# EL PASO COUNTY PLANNING AND COMMUNITY DEVELOPMENT DEPARTMENT

## GRADING AND EROSION CONTROL PLAN CHECKLIST

Revised: July 2019

GRADING & EROSION CONTROL PLAN
CLAREMONT BUSINESS PARK 2 FIL. NO. 1 - LOT 5
JOB NO. 44-037
DATE PREPARED: JULY 17, 2020
DATE REVISED: OCT 27, 2020

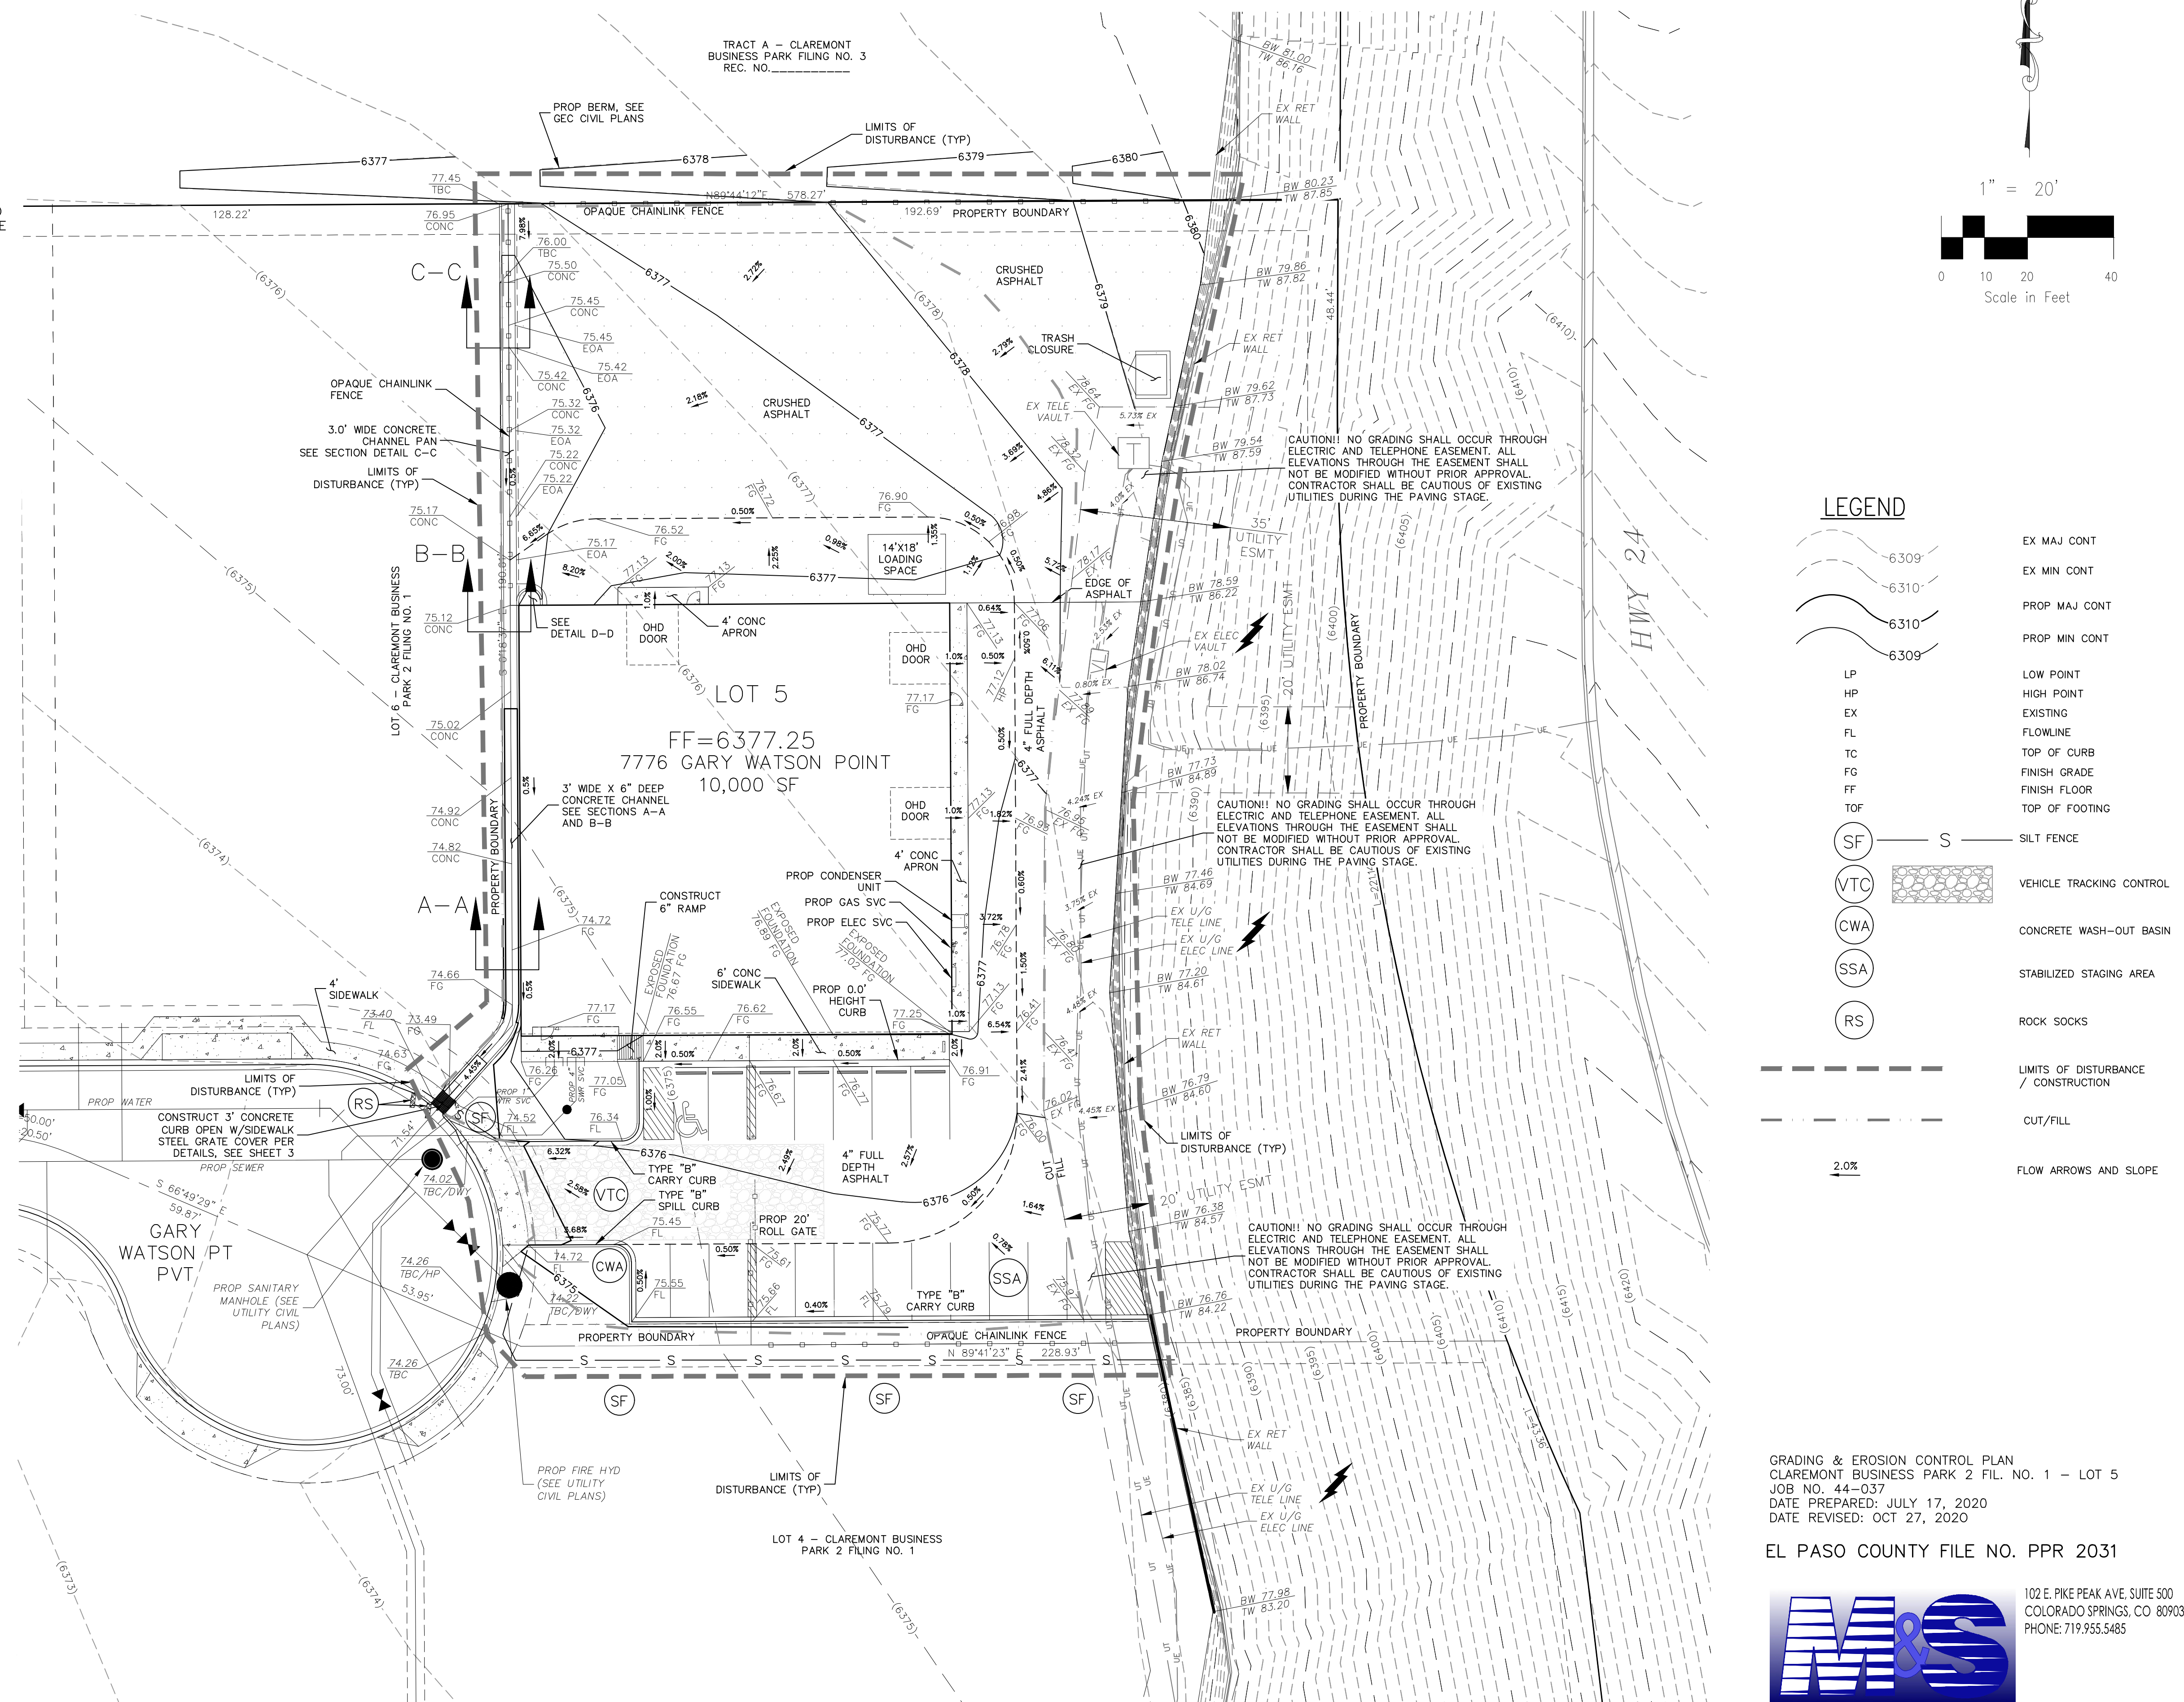
Applicant	PCD
<b>1. GRADING AND EROSION CONTROL PLAN</b>			
a	Vicinity map.	X	✓
b	Adjacent city/town/jurisdictional boundaries, subdivision names, and property parcel numbers labeled.	X	✓
c	North arrow and acceptable scale (1"=20' to 1"=100'). <span style="color: magenta;">Added as requested</span>	X	✓
d	Legend for all symbols used in the plan. <span style="border: 1px solid black; padding: 2px;">Add drainage flow arrows to Legend</span>	X	✗
e	Existing and proposed property lines. Proposed subdivision boundary for subdivision projects.	X	✓
f	All existing structures.	X	✓
g	All existing utilities. <span style="color: magenta;">Limits of disturbance and construction are one in</span>	X	✓
h	Construction site boundaries. <span style="color: magenta;">the same, notes updated as requested.</span>	X	✗
i	Existing vegetation (notes are acceptable in cases where there is no notable vegetation, only grasses/weeds, or site has already been stripped). <span style="color: magenta;">Notes about vegetation added to sheet 2</span>	X	✗

GRADING & EROSION CONTROL PLAN
CLAREMONT BUSINESS PARK 2 FIL. NO. 1 - LOT 5
JOB NO. 44-037
DATE PREPARED: JULY 17, 2020
DATE REVISED: OCT 27, 2020

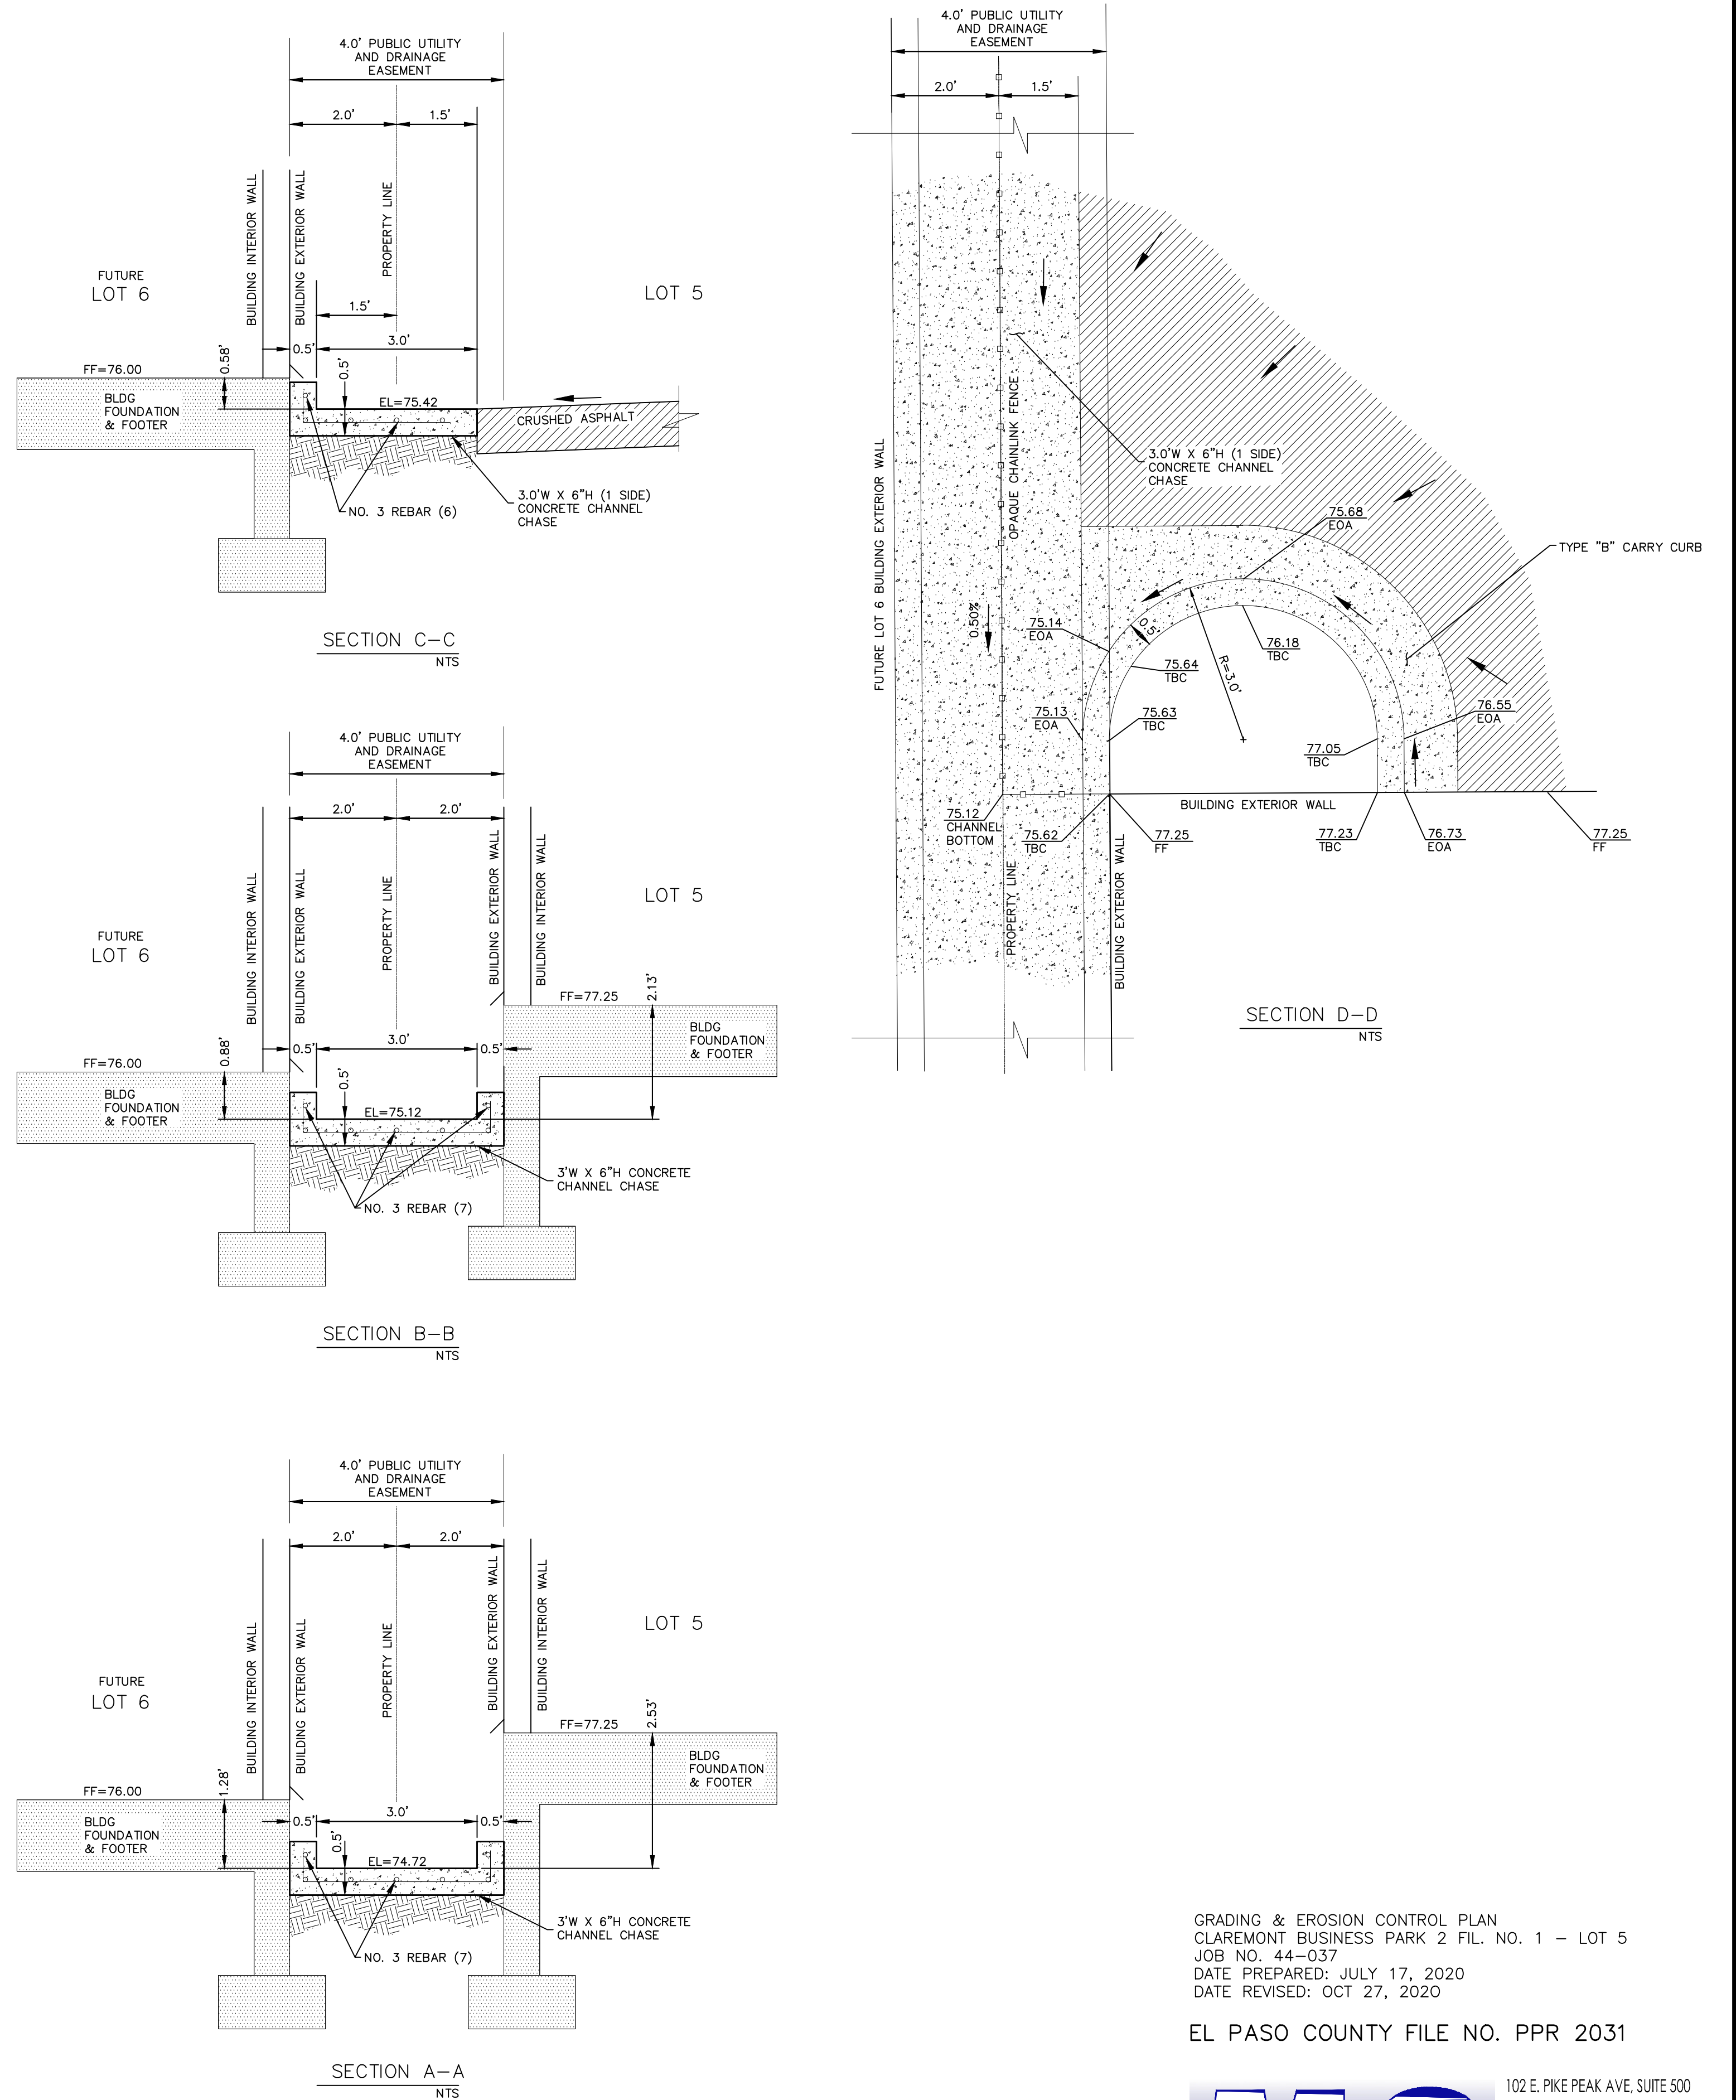
y	Dewatering operations to include locations of diversion, pump and discharge(s) as anticipated at time of design.	N/A	N/A
z	All proposed temporary construction control measure details. Custom or other jurisdiction's details used must meet or exceed EPC standards. <span style="color: magenta;">Details have been added, see sheets 3 &amp; 4</span>	X	✗
